From: BRYAN BUTCHER [REDACTED]
Sent: 19 July 2021 09:31
To: Planning.Responses [REDACTED]
Subject: Re: Request for further information BE/115/21/HH

I am pleased to attach the amended plan.

sheet 2 a of 3

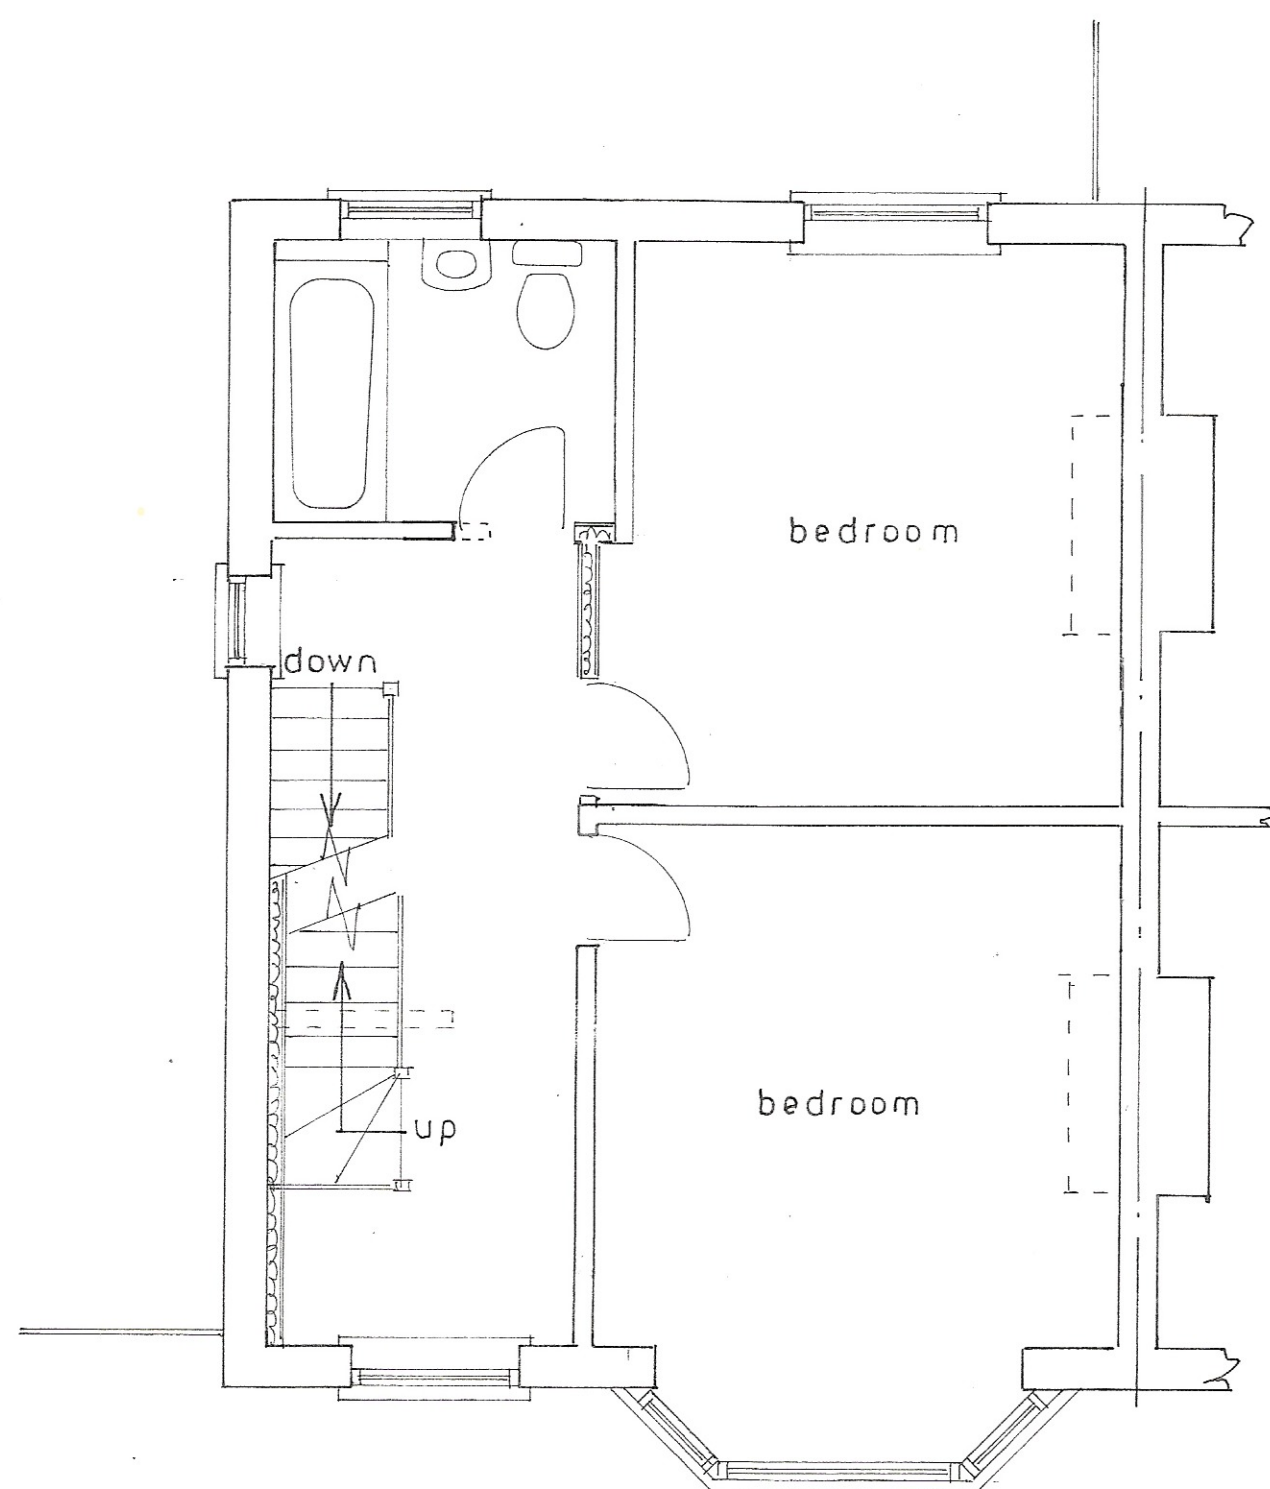
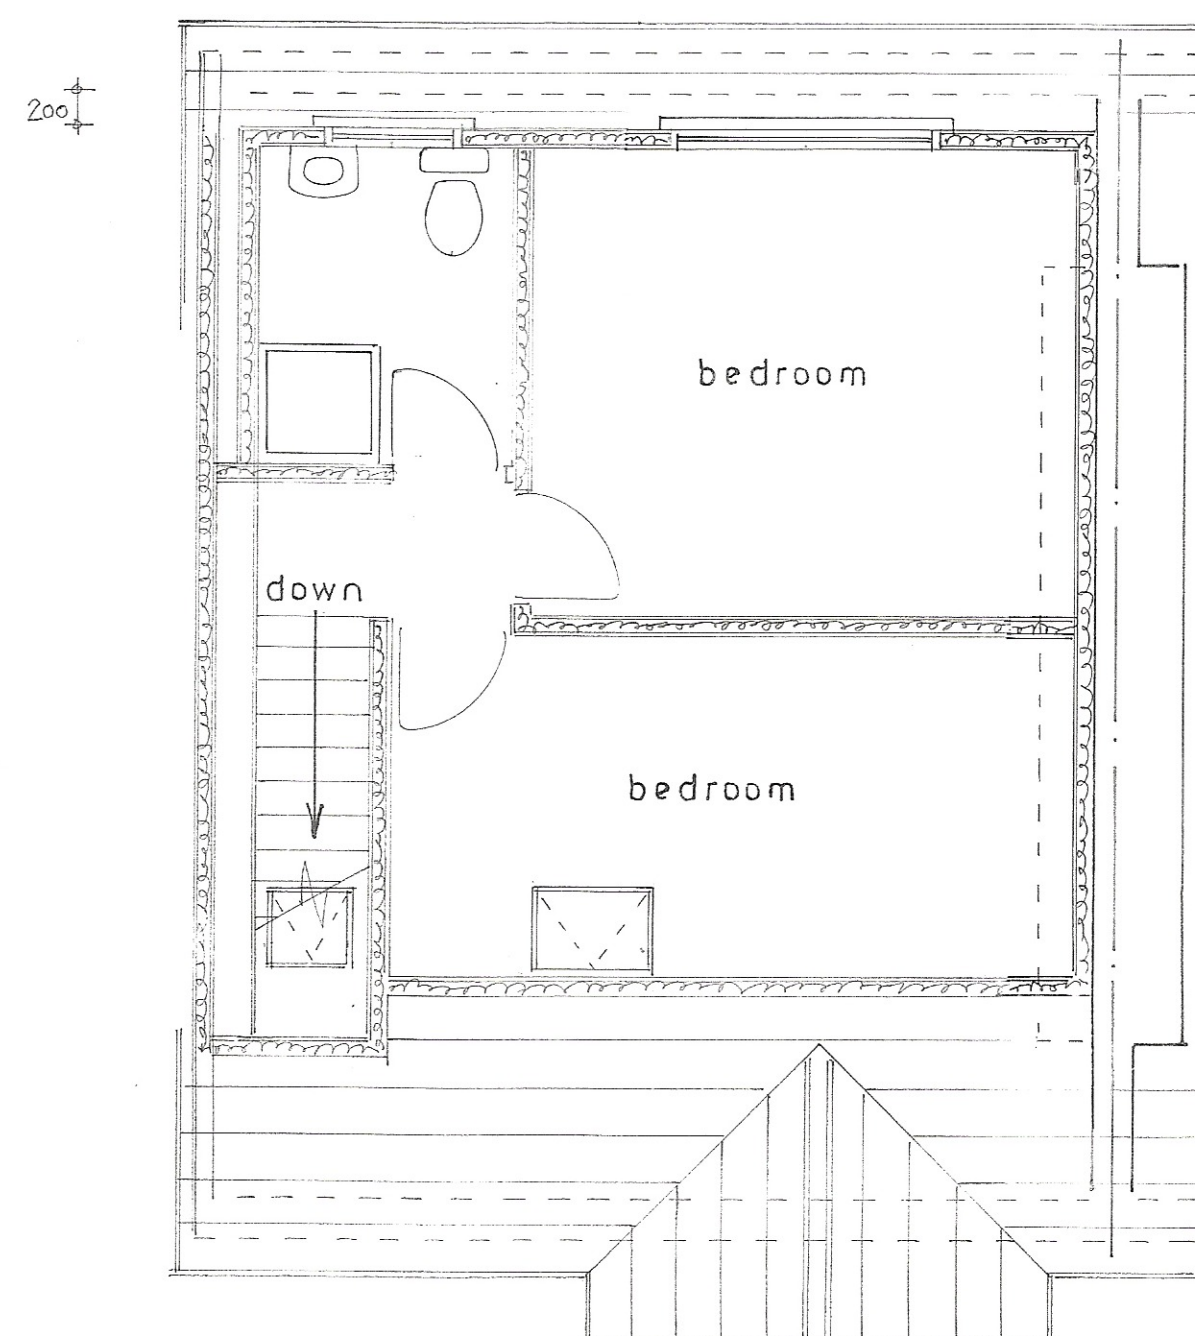
The window openings are actually 1800mm and 900mm which I have now detailed their sizes on the plan.
